6 November 2013

Re: Application No: MP07_0158 MOD 3 - Objection to Modification Request for the University of Sydney Abercrombie Precinct Redevelopment – Proposed Student Housing Building

Sheridan Planning (**SP**) is acting on behalf of Mandelbaum House, a residential college which adjoins the site of the proposed Student Housing Building on the Abercrombie Precinct at the southern end of the Darlington Campus, University of Sydney. **SP** has been engaged to review the above modification application and prepare a submission to the Department on behalf of Mandelbaum House.

Shadow Diagrams
winter solstice - June 21
11.10.13
4001_DA07-D

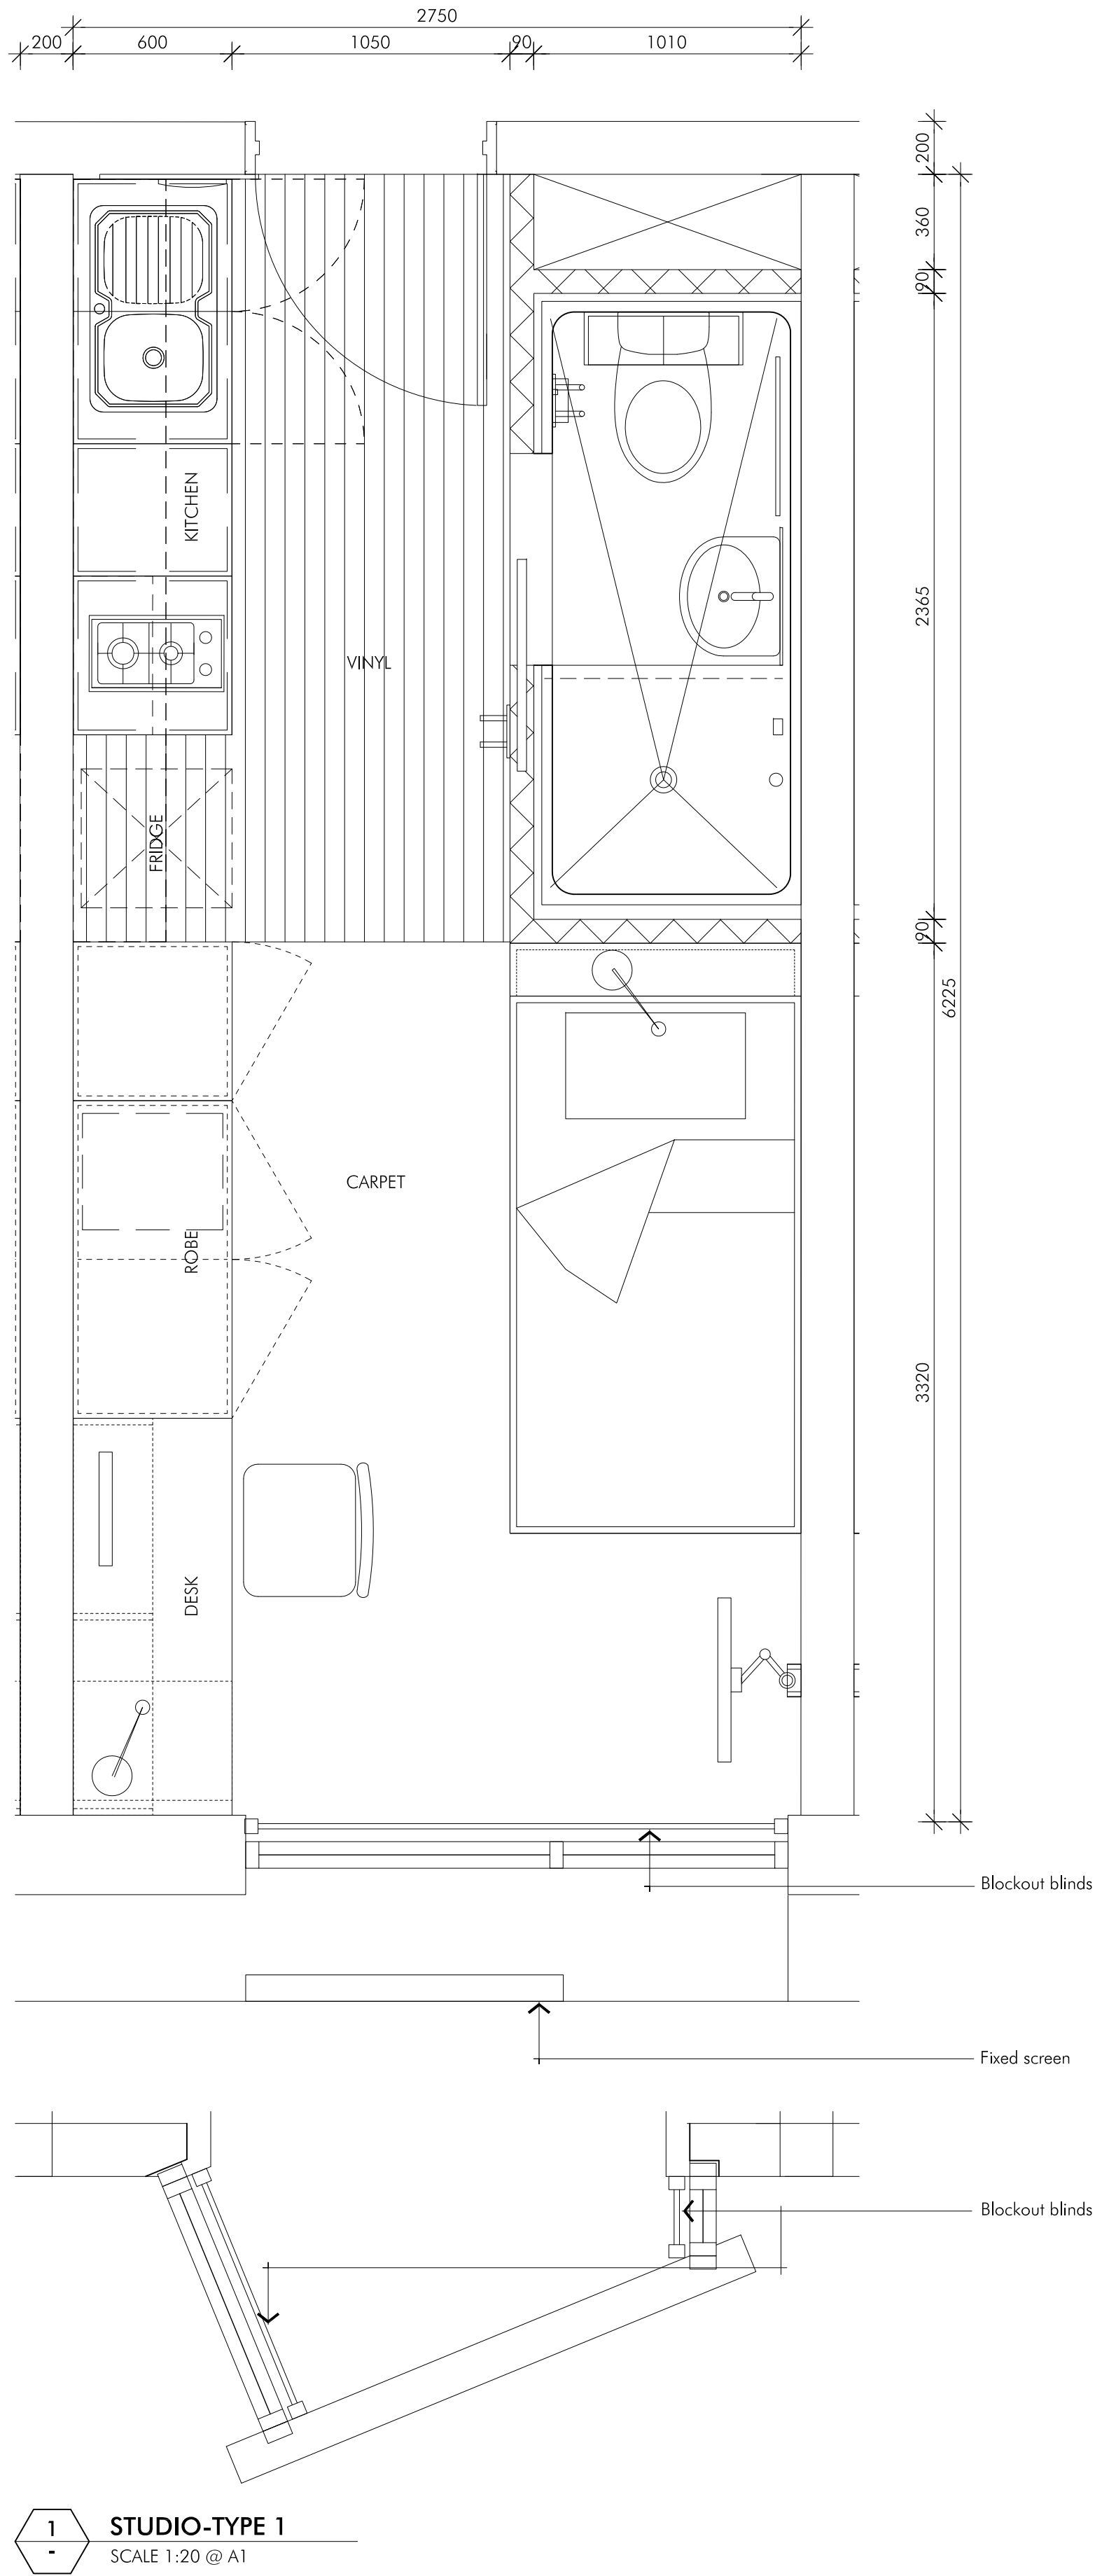
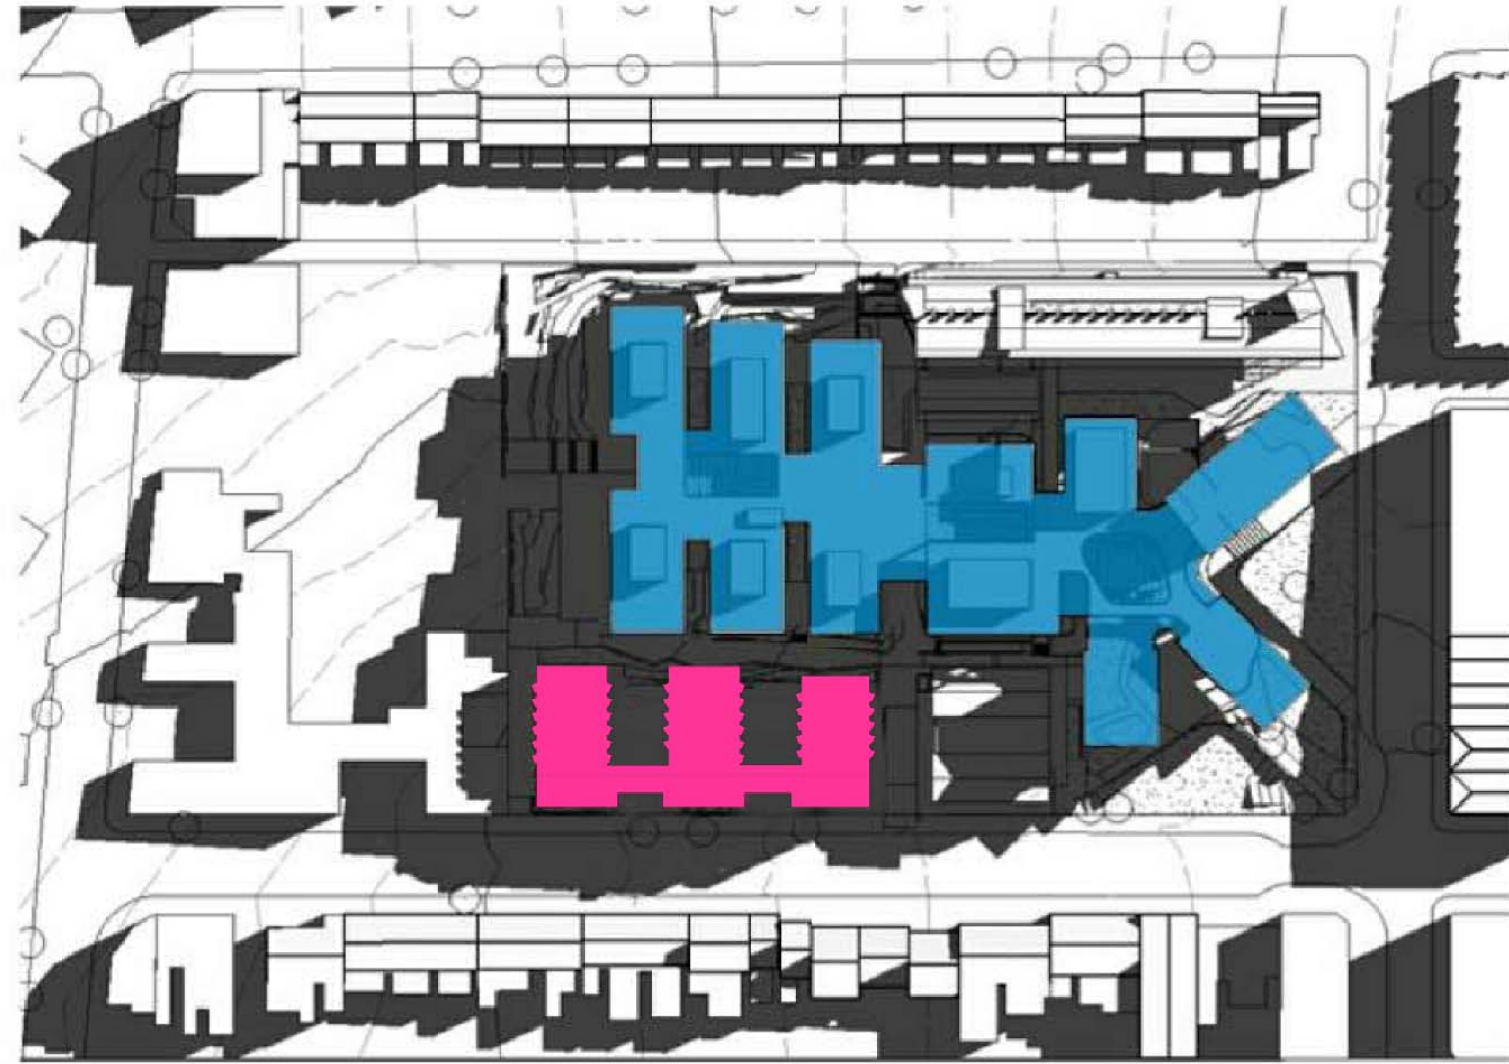
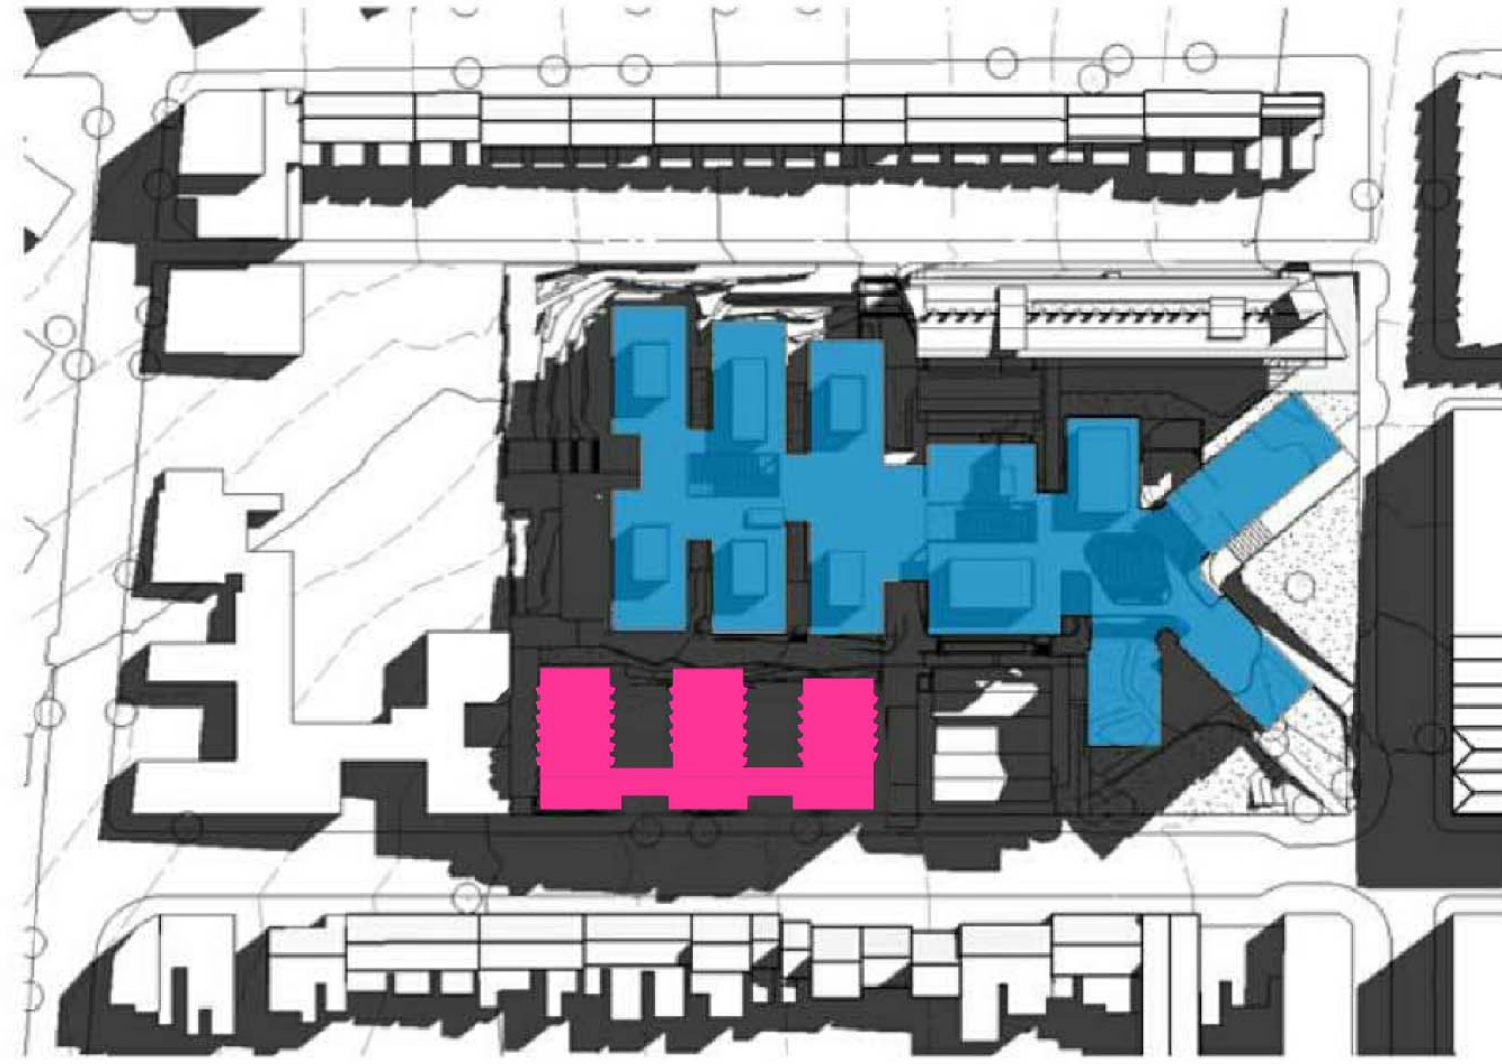
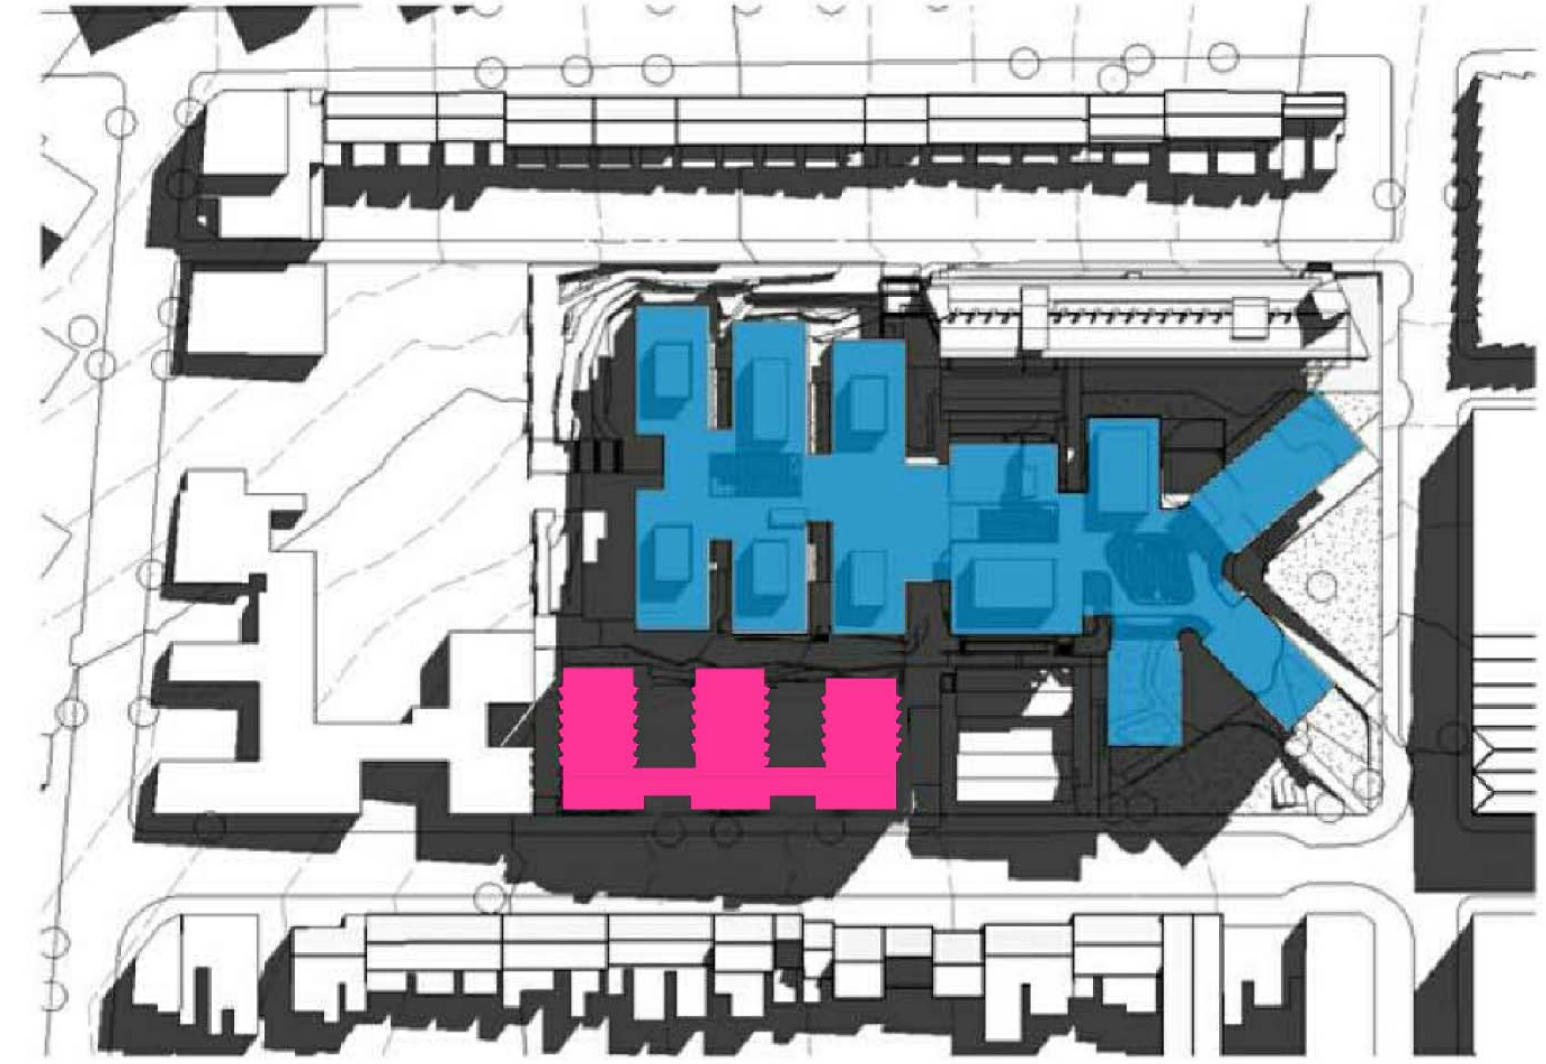
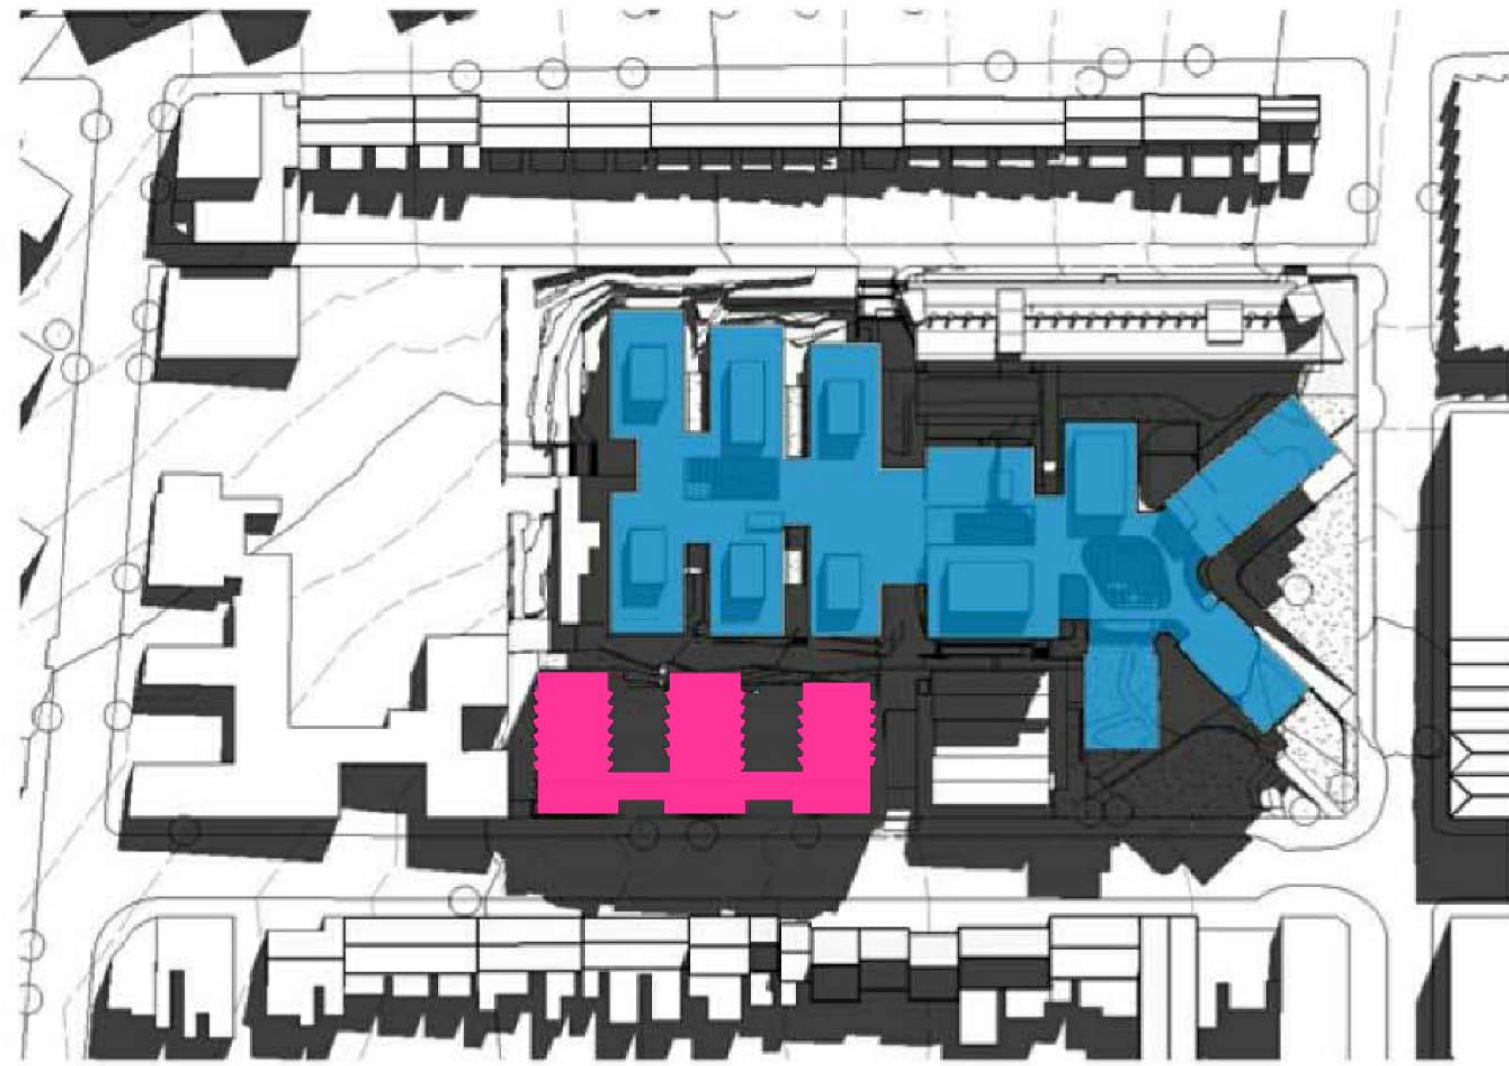
The shadow diagrams submitted indicate that large parts of Mandelbaum House will be in shadow for much of the day which will materially affect the amenity of Mandelbaum House's students. The buildings surrounding Mandelbaum House will also be closer and substantially higher than the existing buildings, causing loss of sunlight and privacy in the students' rooms, the existing patios and terraces.

The proposed Student Housing Building coupled with the cumulative impacts of the Business School will have a devastating impact on Mandelbaum House in terms of loss of sunlight and daylight. The proposal clearly falls well short of maintaining the College's current levels of residential amenity. The existing Dining Room Patio and Library Patio face the Student Housing Building will be overshadowed, which will impact on amenity and the student's enjoyment of these areas.

The overshadowing impacts of the development can be ameliorated to a degree by simply stepping back of the top two levels of the proposed Student housing building, away from the eastern boundary. The setting back of the upper levels of the proposed buildings will also assist in minimizing the potential overlooking issues.

- The top two levels of the proposed Student housing building are to be set well back from the eastern side boundary, to minimise the overshadowing and privacy impacts on Mandelbaum House.
